Re: BP#2017-00012 - 23 Ocean Avenue - Further plan review comments

- 23 Ocean Code Analysis
 - I have updated the analysis to more clearly describe the parking. It was initially included in the comments column. It has now been included in the main body of the table. The basement storage has also been added. A column has been added with an asterix to indicate which lines have been edited.

SK-1

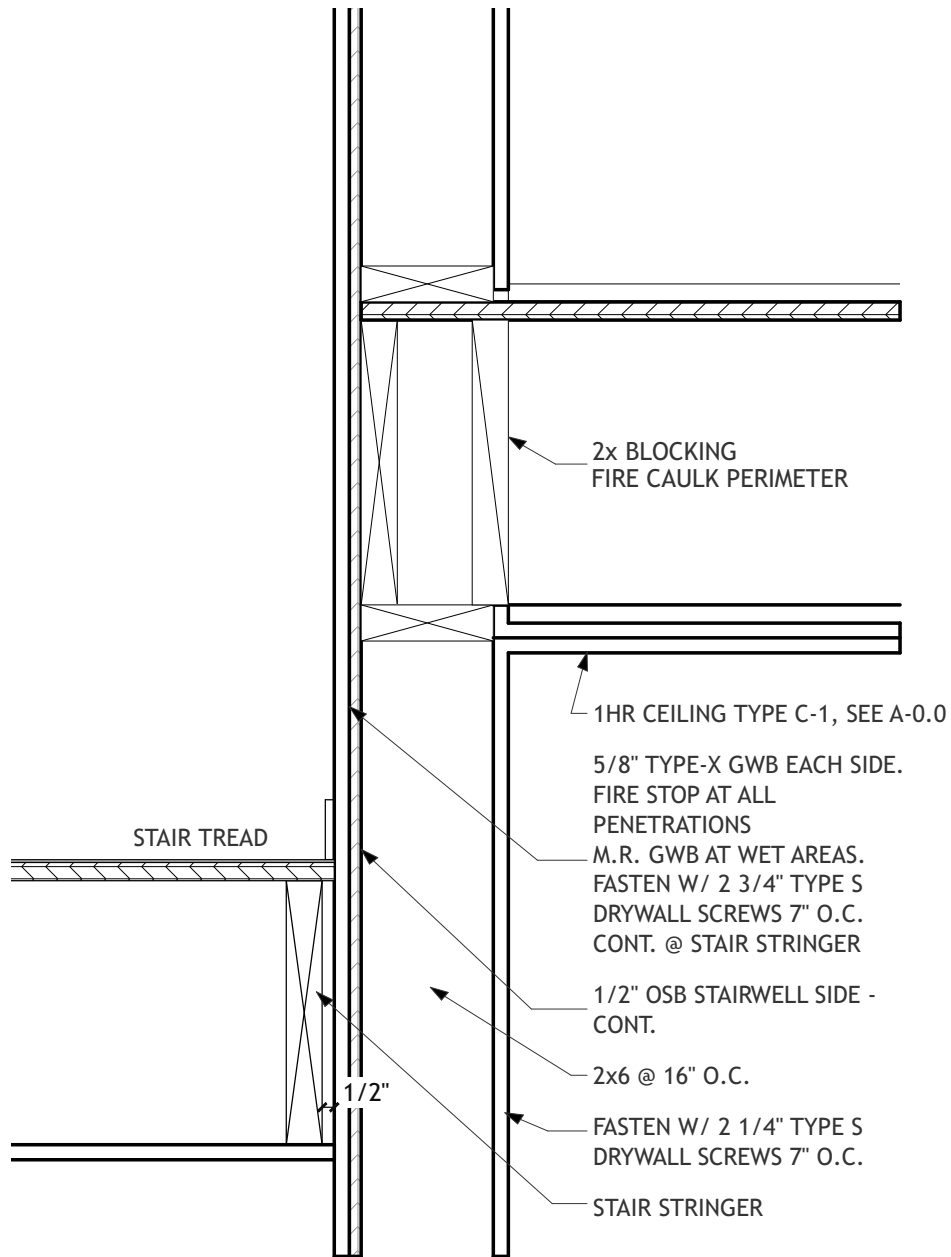
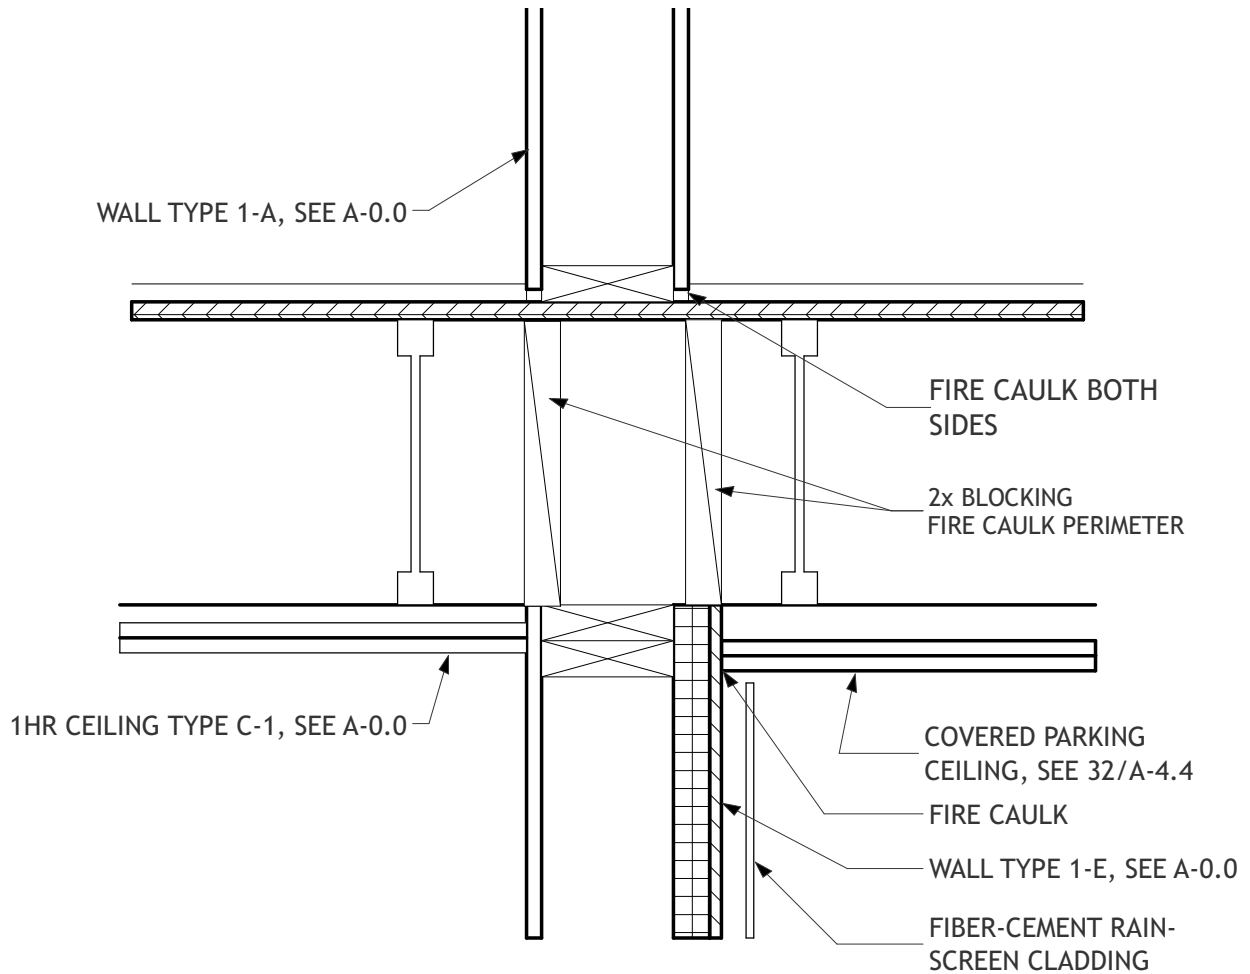
- For clarity the rated assemblies have been shaded in the section drawings.
- A-4.3 Details
 - Incorporates the edits requested.
- SK-01, SK-02, SK-03
 - Attached details of separation continuity to address your comment on A-3.1

12/14/2016  
**A-3.1**  
 11 of 17

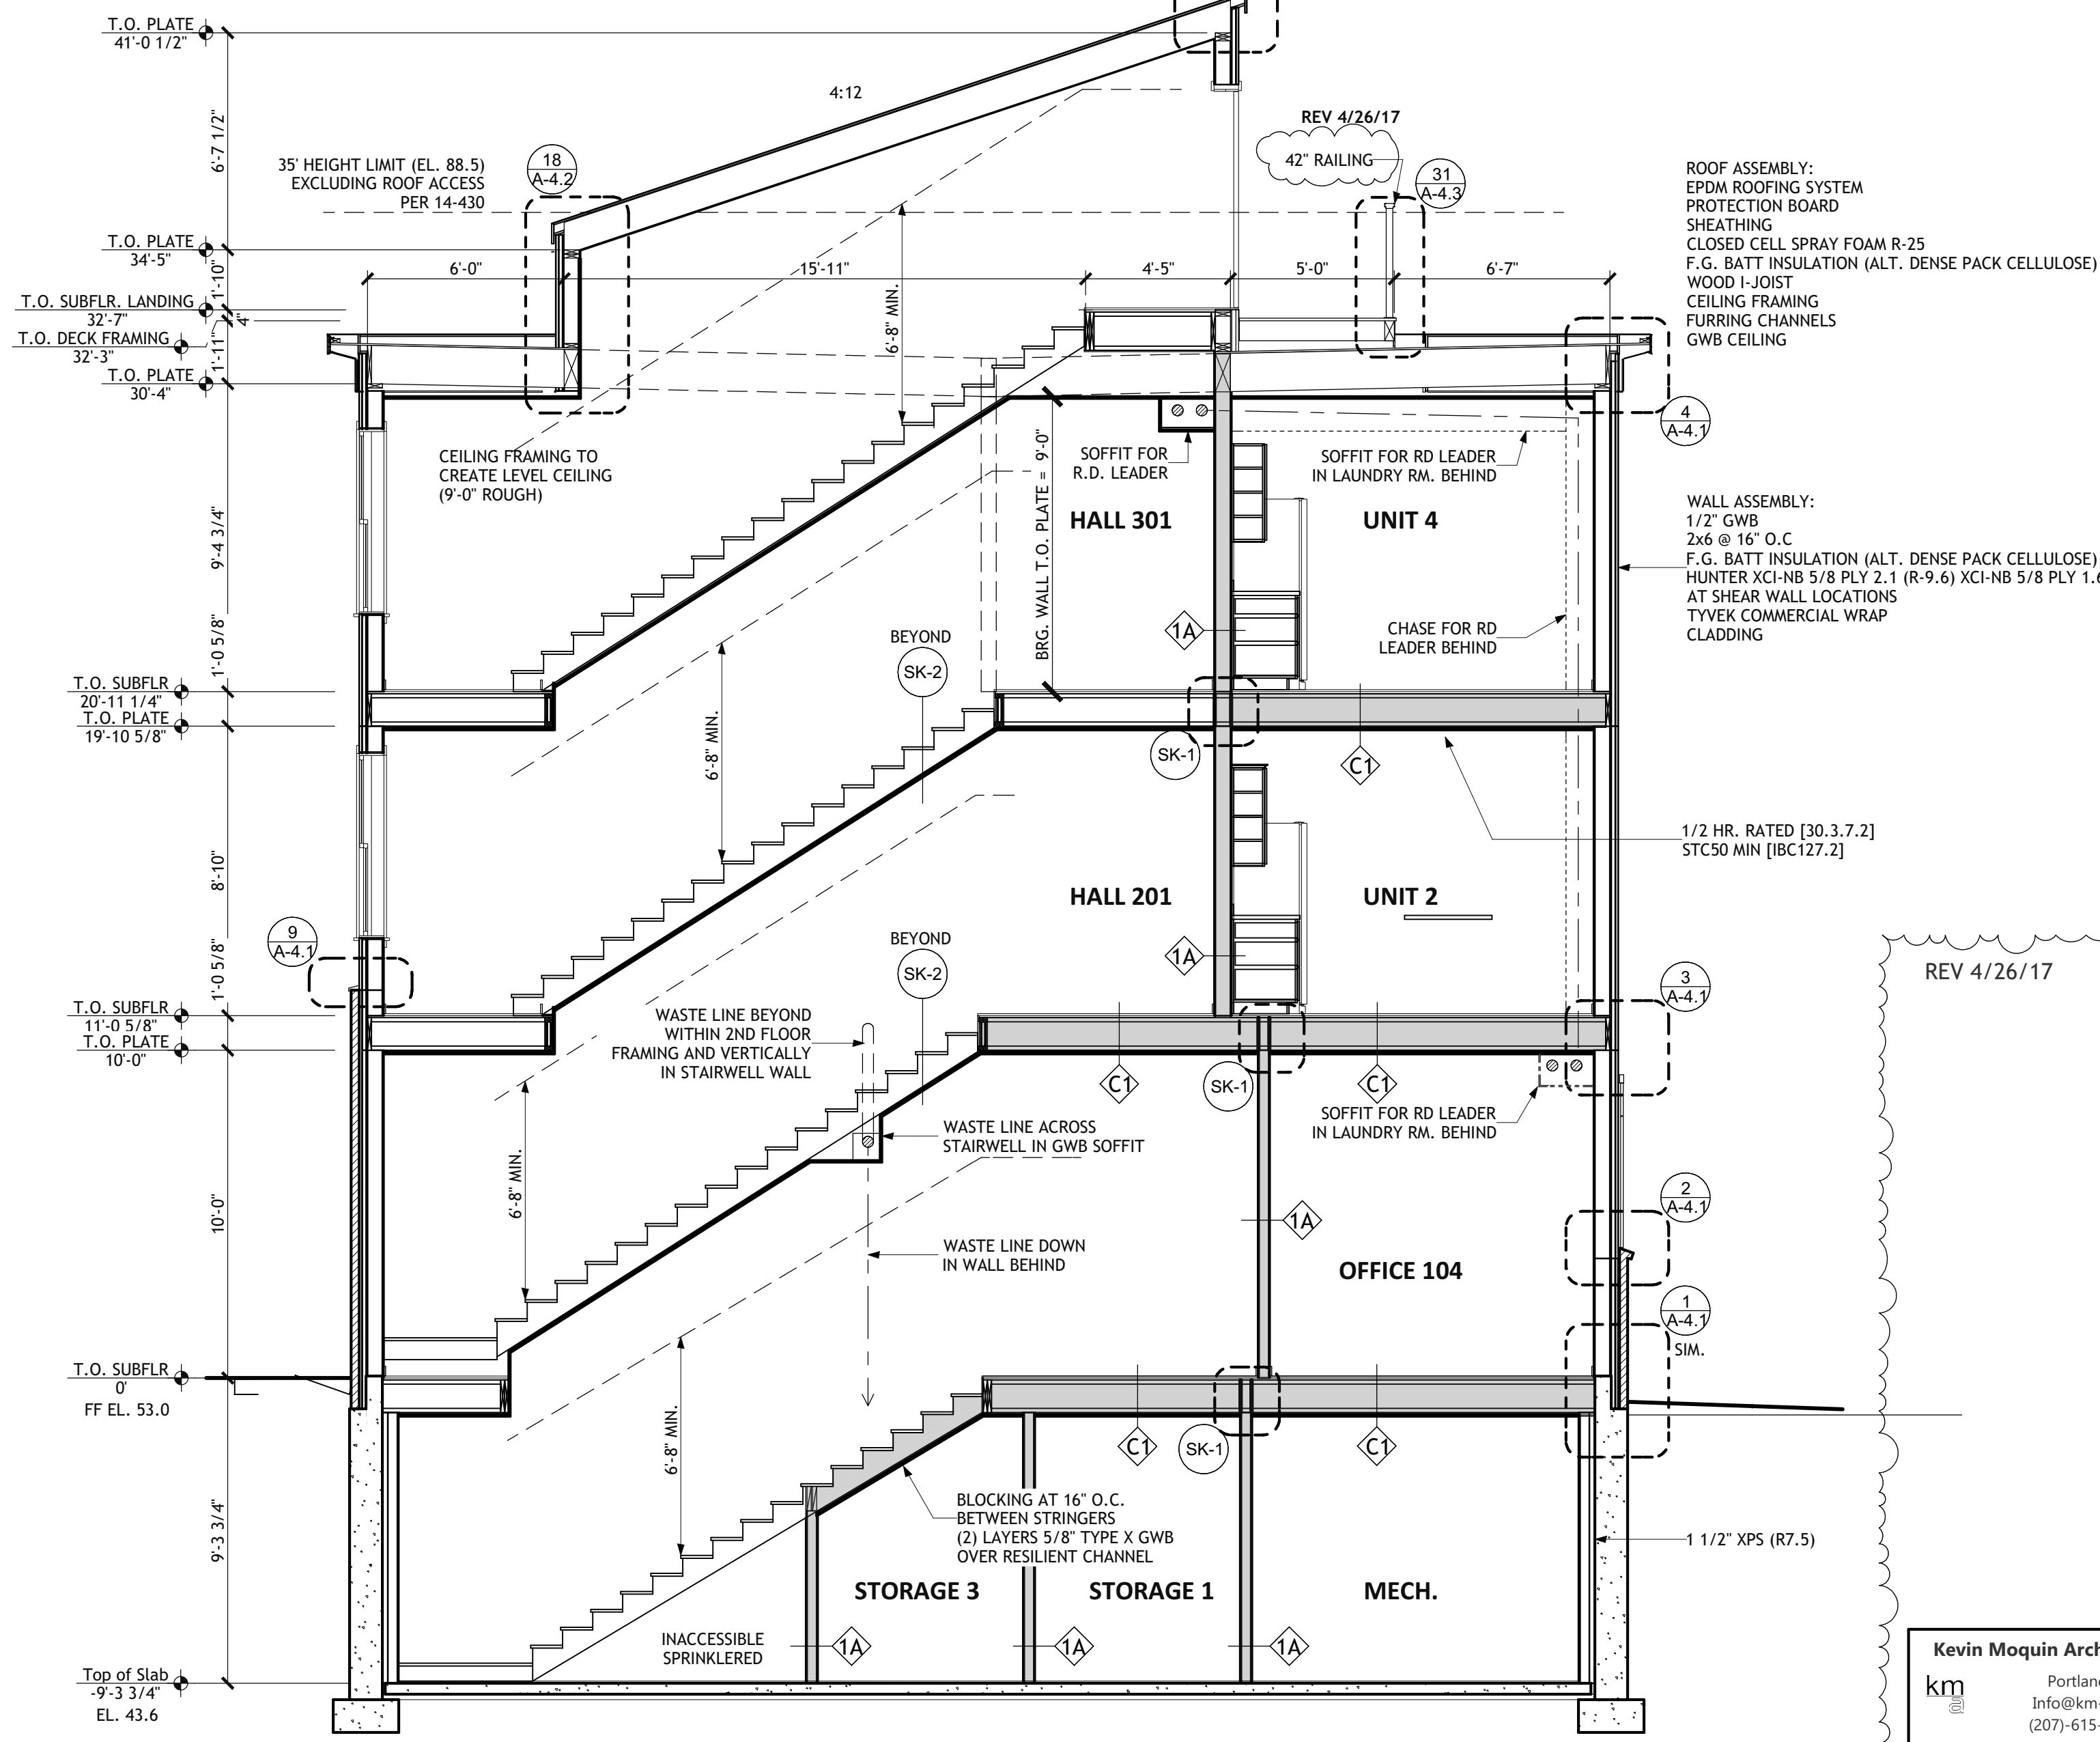
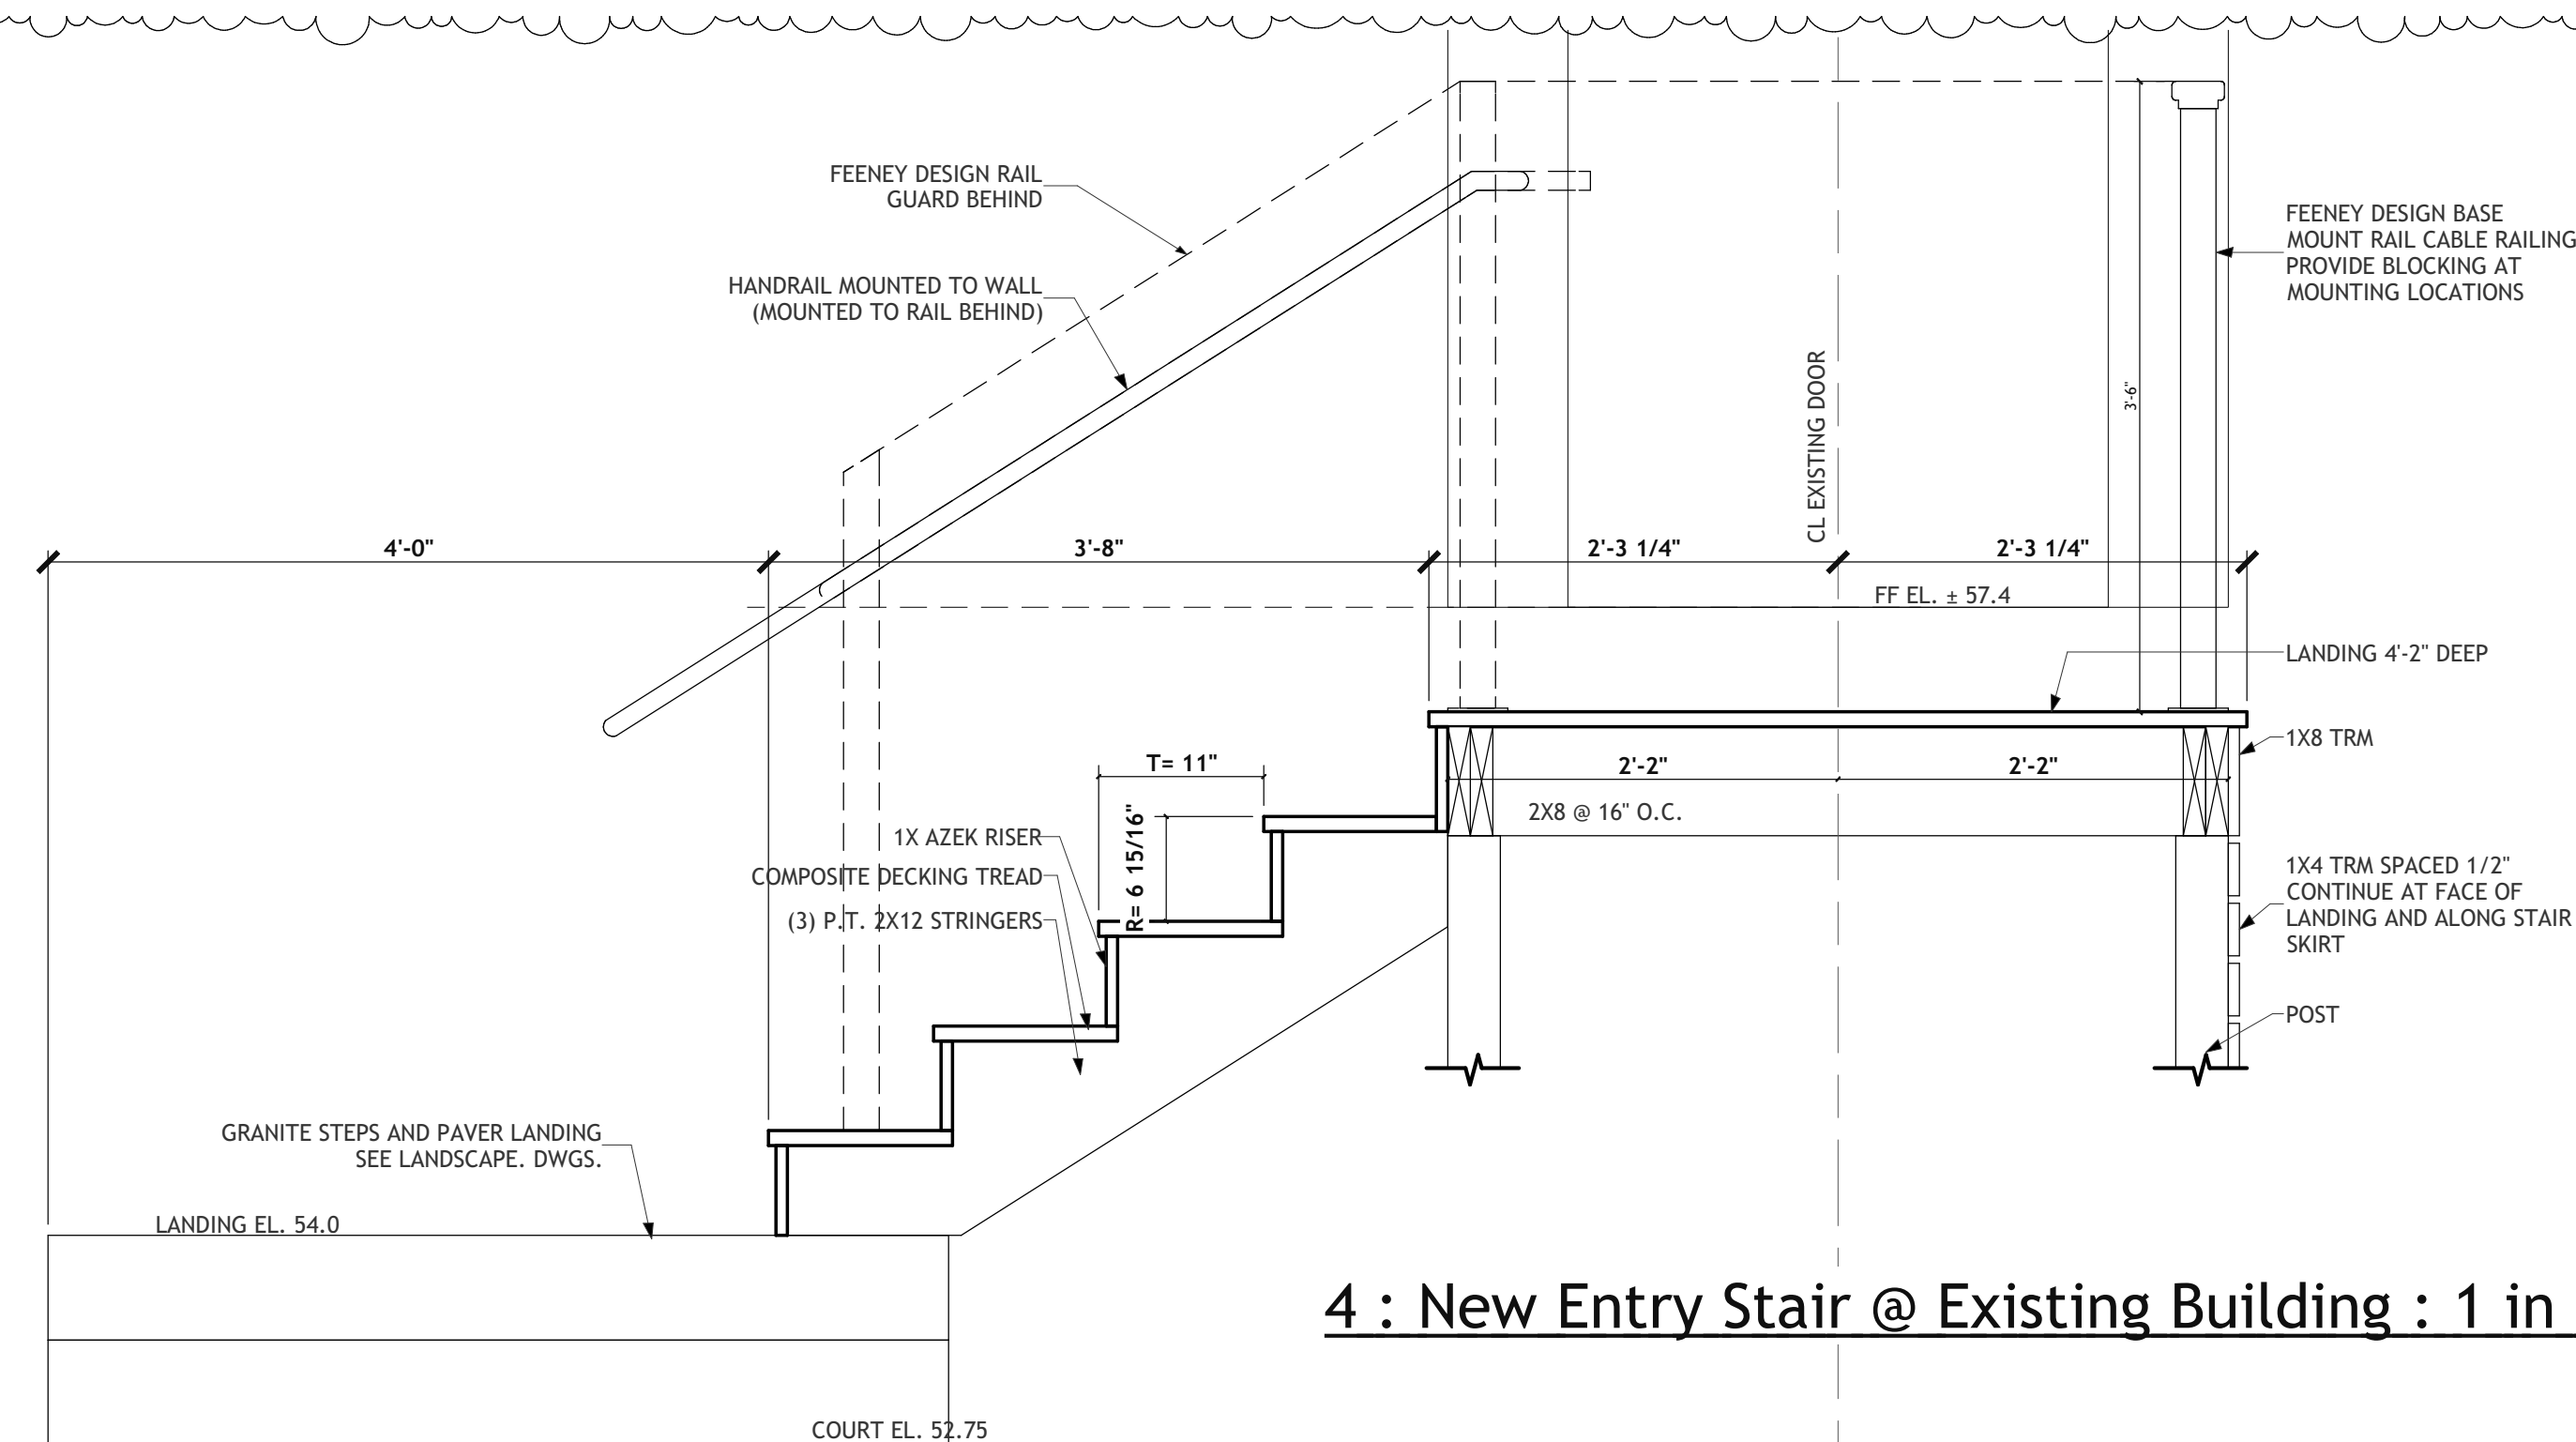
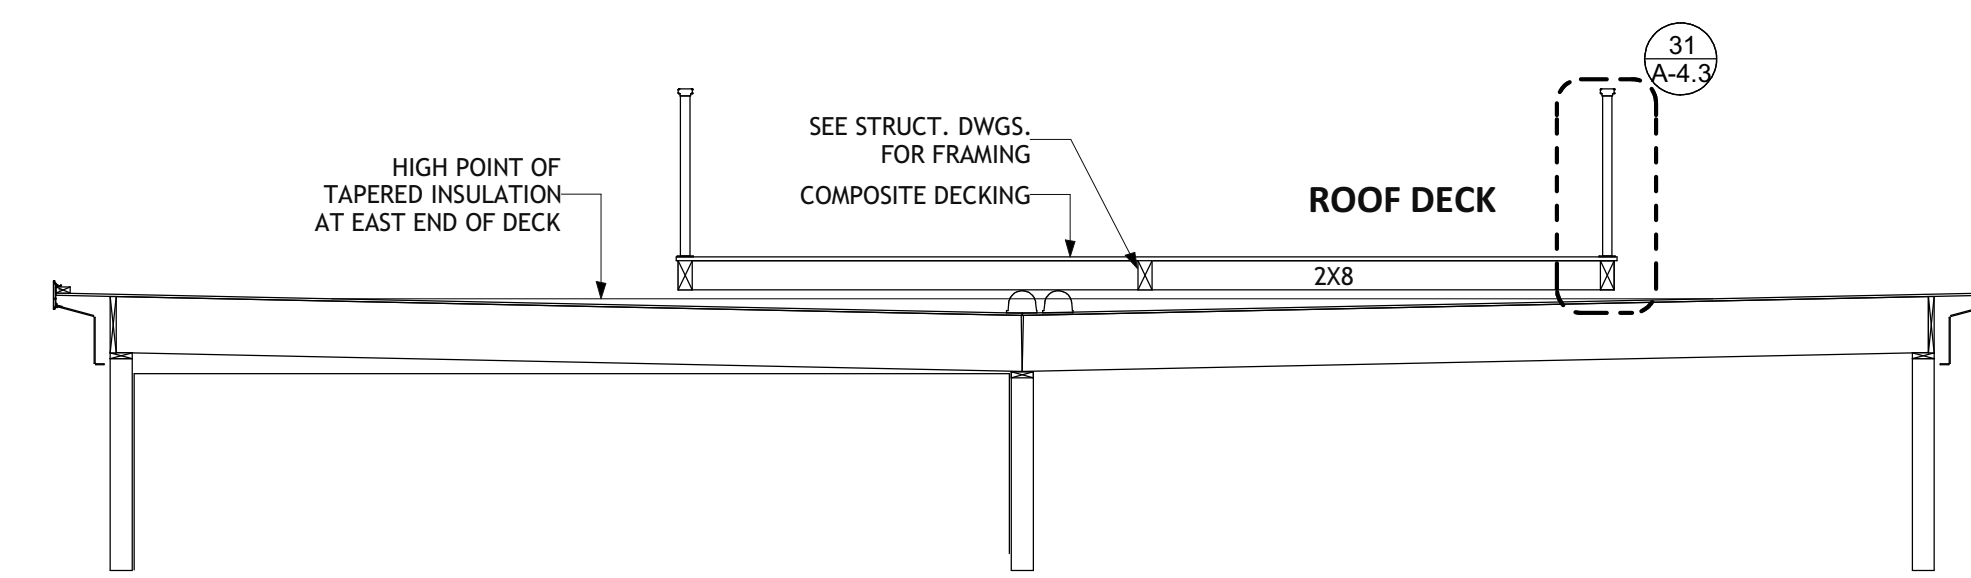
- A-3.1 Building Sections
 - Incorporates the edits requested.
 - In section 1, the underside of the stair in the storage room is scheduled to receive 2 layers of 5/8" type X GWB over resilient channel. (Noted on 1/A-3.1)
